From: Polly Harris-Gorf
Sent: 05 May 2022 14:59
To: _planningadvice
Subject: FW: 21-L74 - PLOT 9 HOLBEACH - REF: H09-0253-22
Attachments: We sent you safe versions of your files; Visqueen_Radon_R400_Membrane_datasheet.pdf; 21-L74-PL006 - AJS - PROPOSED SECTION AND DETAILS.pdf

From: Harley Cooper <harley@trundley.com>
Sent: 05 May 2022 14:55
To: Polly Harris-Gorf <pharris-gorf@sholland.gov.uk>
Cc: Armour, Susan <Susan.Armour@sholland.gov.uk>; Ian Trundley <ian@trundley.com>; Lauren Cooper. <admin@trundley.com>
Subject: RE: 21-L74 - PLOT 9 HOLBEACH - REF: H09-0253-22

PLOT 9, HOLBEACH
SOUTH LINCOLNSHIRE FOOD ENTERPRISE ZONE

Drawing Title:
**PROPOSED OFFICE AND WORKSHOP
WITH ASSOCIATED WORKS
PROPOSED ROOF PLAN AND SECTIONS**

Drawing Title:  
**PROPOSED OFFICE AND WORKSHOP  
PROPOSED GROUND FLOOR SLAB  
GAS PREVENTION PLAN & PENETRATION DETAILS**

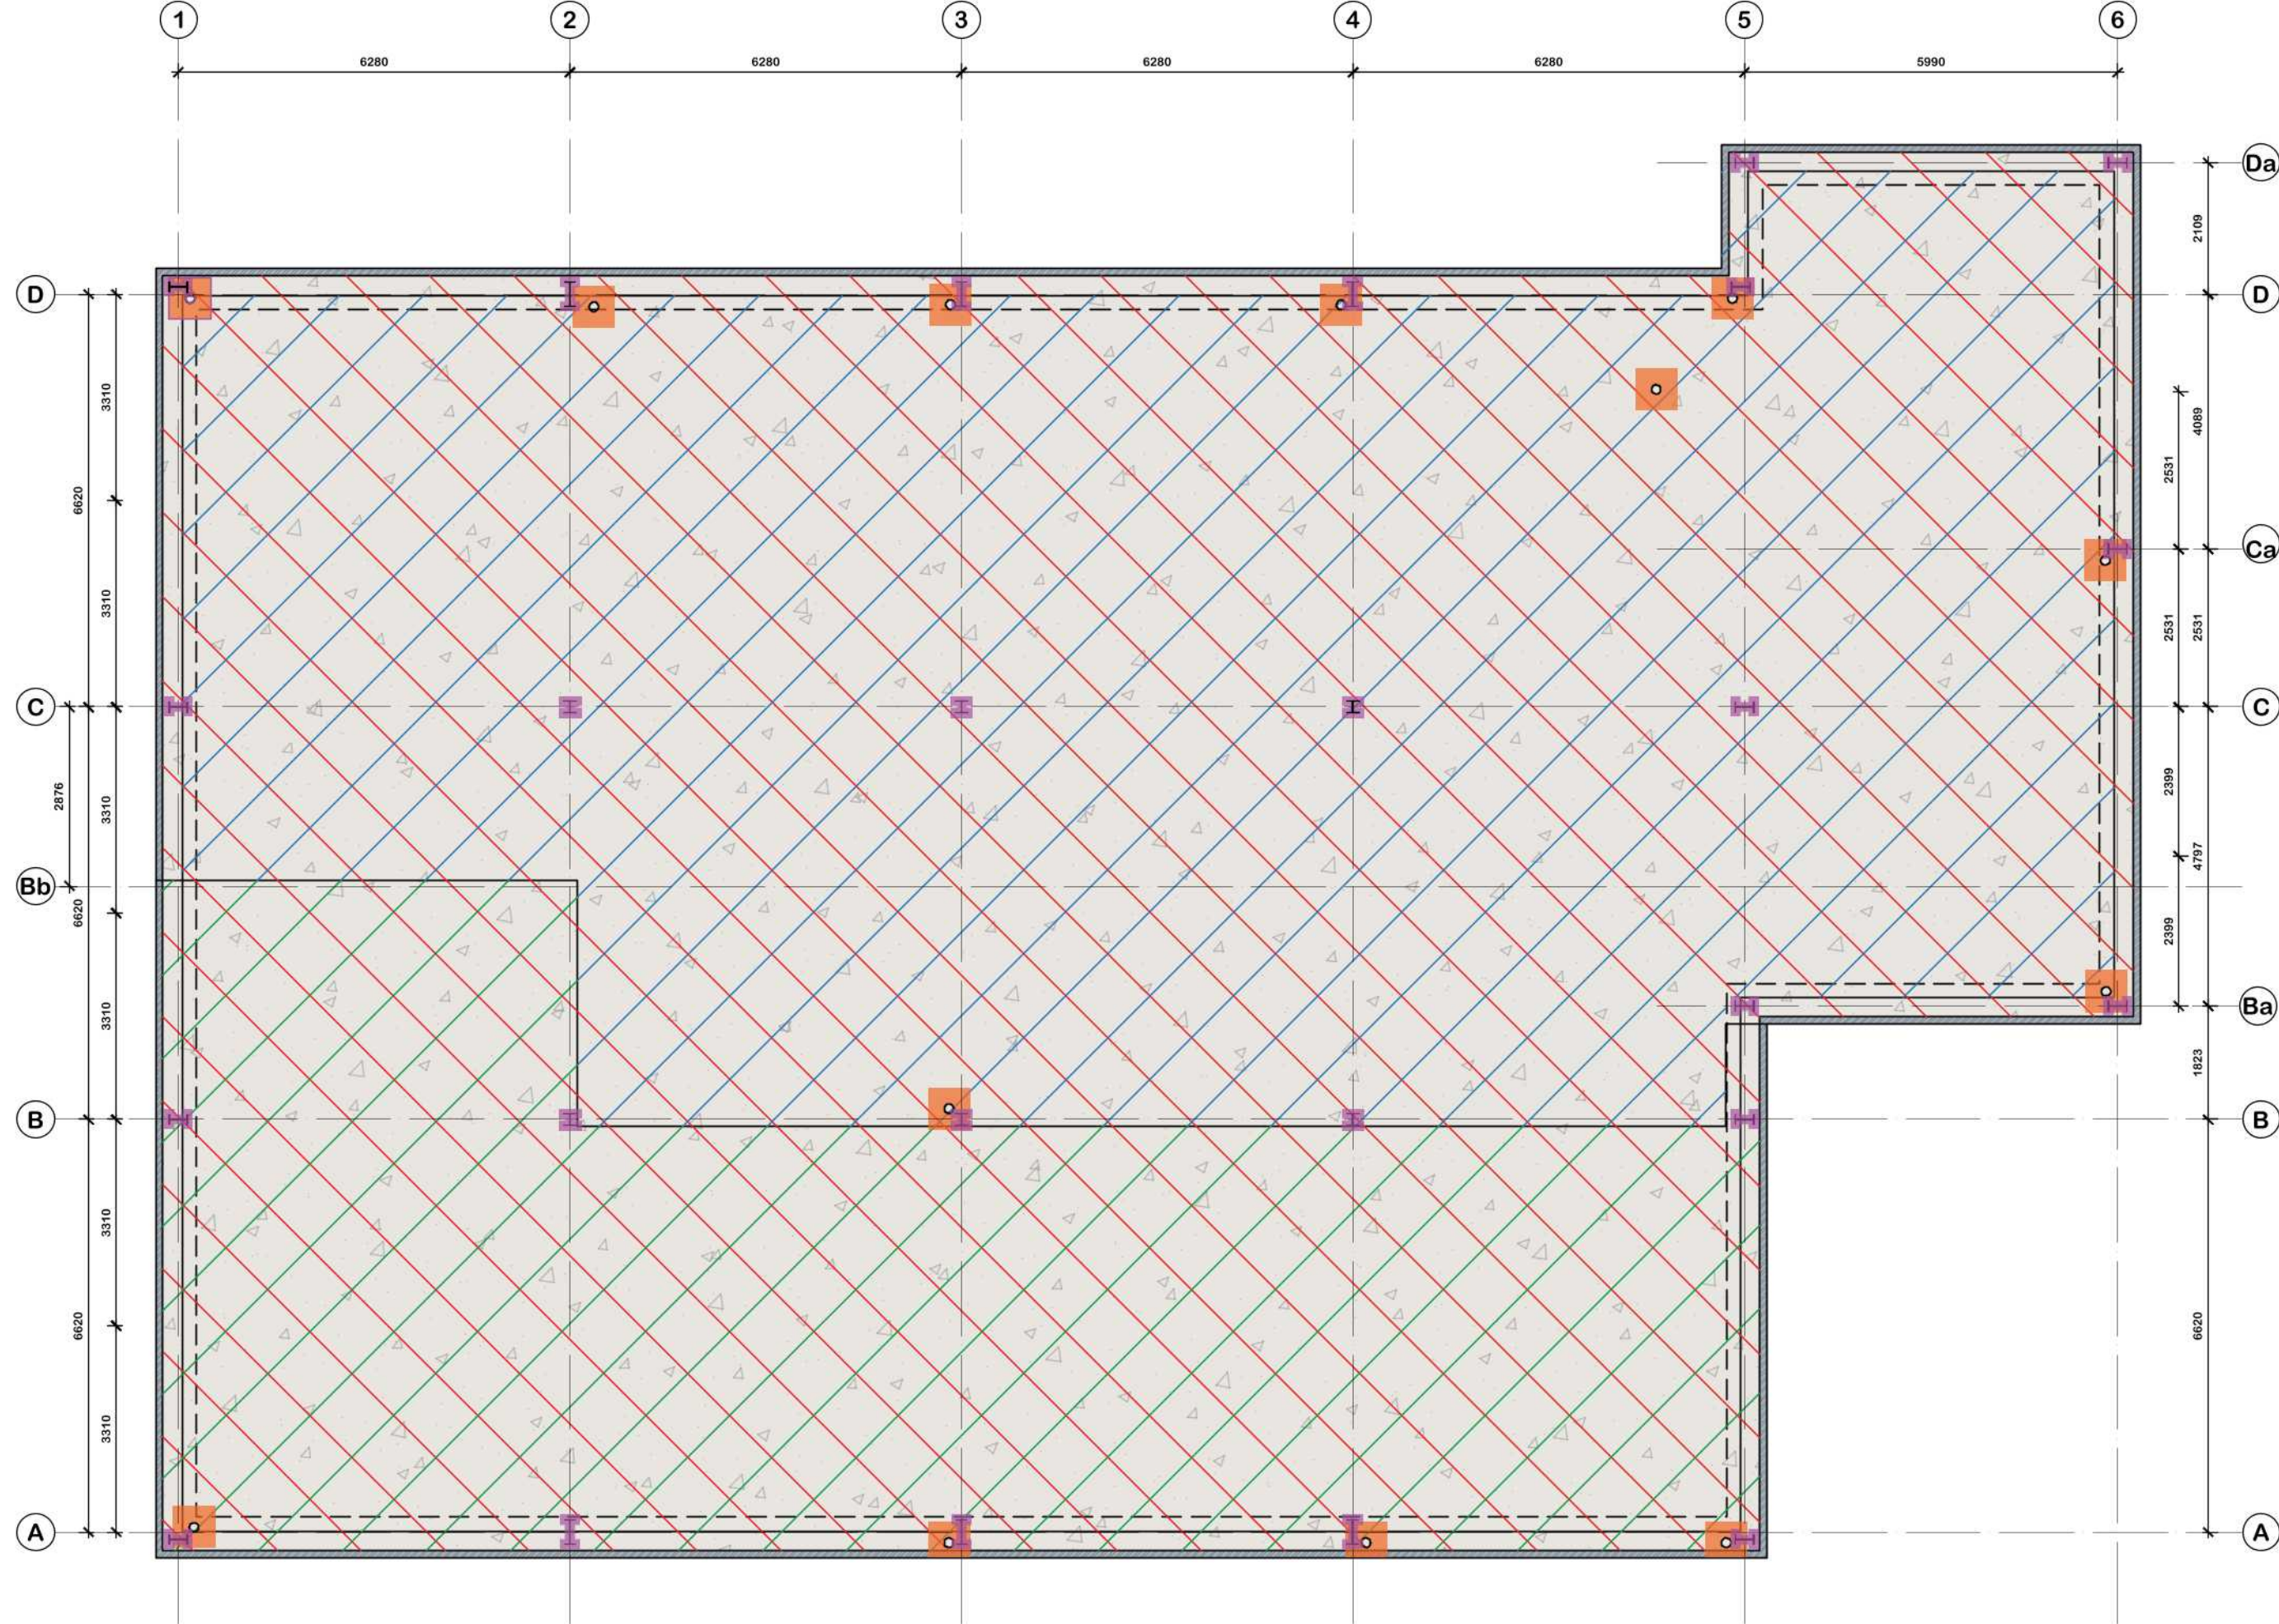
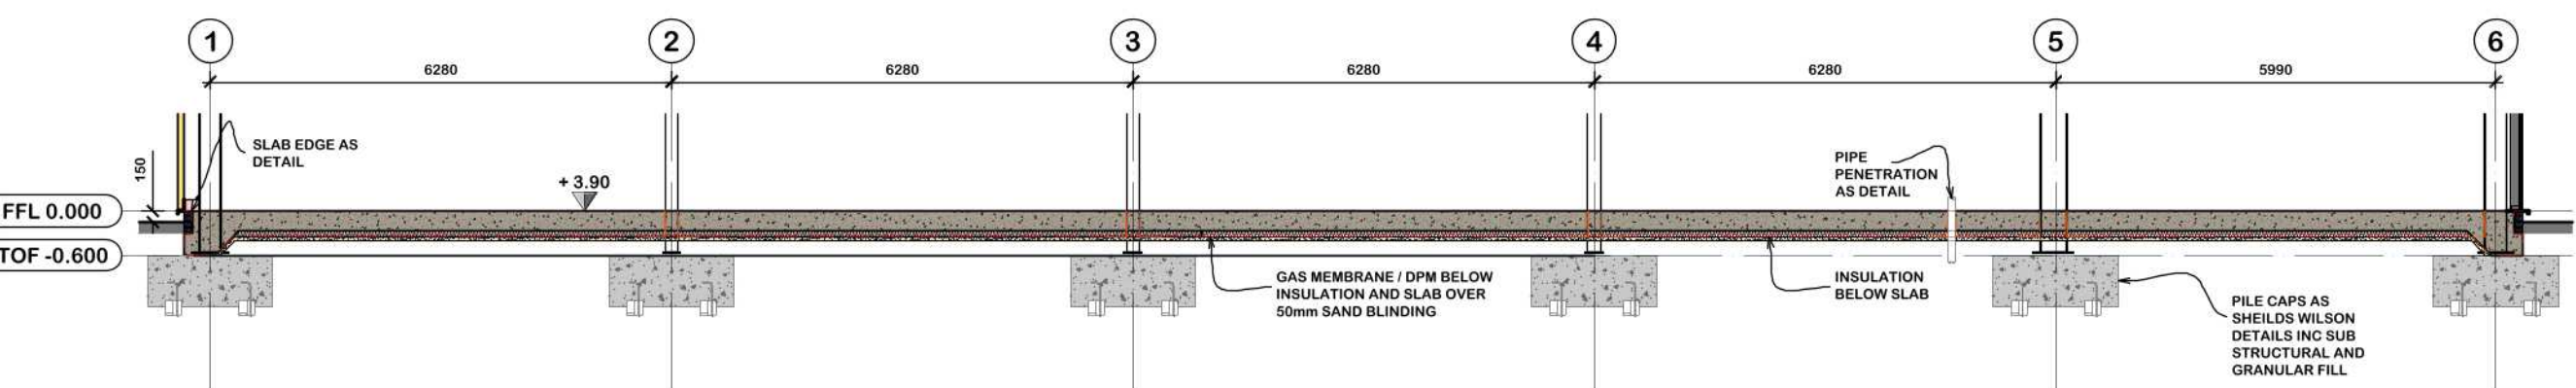
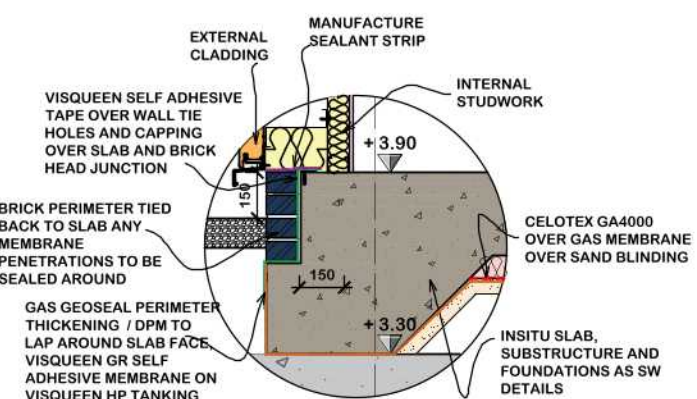
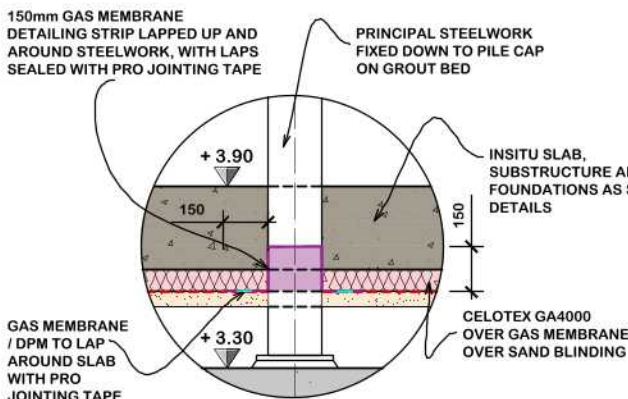
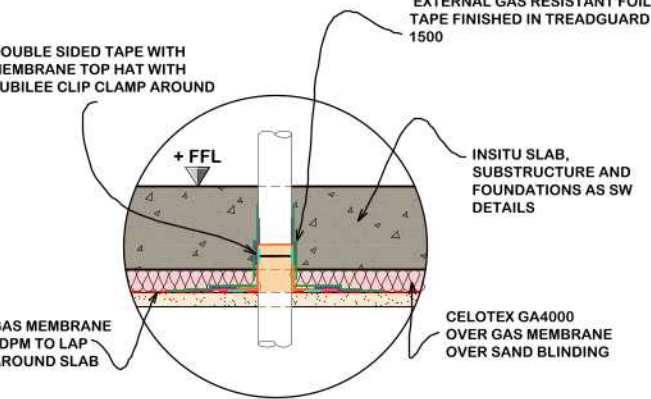
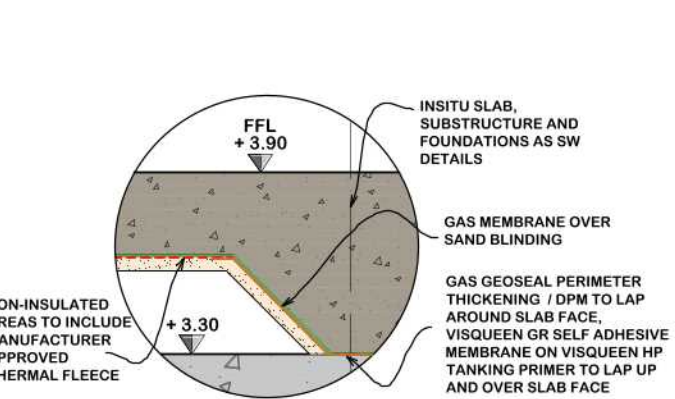
- Please could I see the slab edge/ wall detail?
- Exactly which membrane do they propose to use please?
- In order to achieve a score of 2 (Table 7 of BS8485:2015+A1:2019) for the membrane, it needs to be verified in accordance with CIRIA C735. Will this be undertaken please? I would expect that report to be submitted along with the delivery notes for the membrane and associated consumables (tape etc) as part of any validation report.

They need to achieve a score for the membrane because in section 7.1 it states that a combination of two or more types of protection measures should be used to achieve the score, so they can't rely on a score of 1.5 for the slab being sufficient.

- **Item 1** - Please find attached drawing 21-L74-PL006 which will be a construction issue section drawing showing the extents of the Radon barrier dashed in red. The detail shown is to cover the full extents of the building footprint and is lapped up the perimeter slab as per the enlarged detail.

- **Item 2** - Proposed membrane will be a Visqueen Radon R400 membrane, lapped with 150mm joints and bonded with Visqueen Pro Double Sided Tape and sealed with either Visqueen Pro Single Sided Tape or Visqueen Gas Resistant Foil Lap Tape. Please note this is included within the specification for contractors. This system acts as a radon barrier and DPM, data sheet attached for your reference.

- **Item 3** – As mentioned previously via email 12.04.22 we believe a score of 1.5 is required in accordance with Table 3 of BS8485 for a Type D (CS2) building which is achieved via a reinforced cast insitu monolithic slab with minimal penetrations. The Environmental Site Assessment Report states that Radon protection measures are not considered necessary for this development, however, in order to utilise two types of gas prevention measures we have specified a radon barrier as an addition in accordance with CIRIA RB17 and BS8485:2015+A1:2019. We would not expect to produce further reports as the design exceeds the minimum requirement and the specification is fixed and the manufacturers installation details must be adhered to.
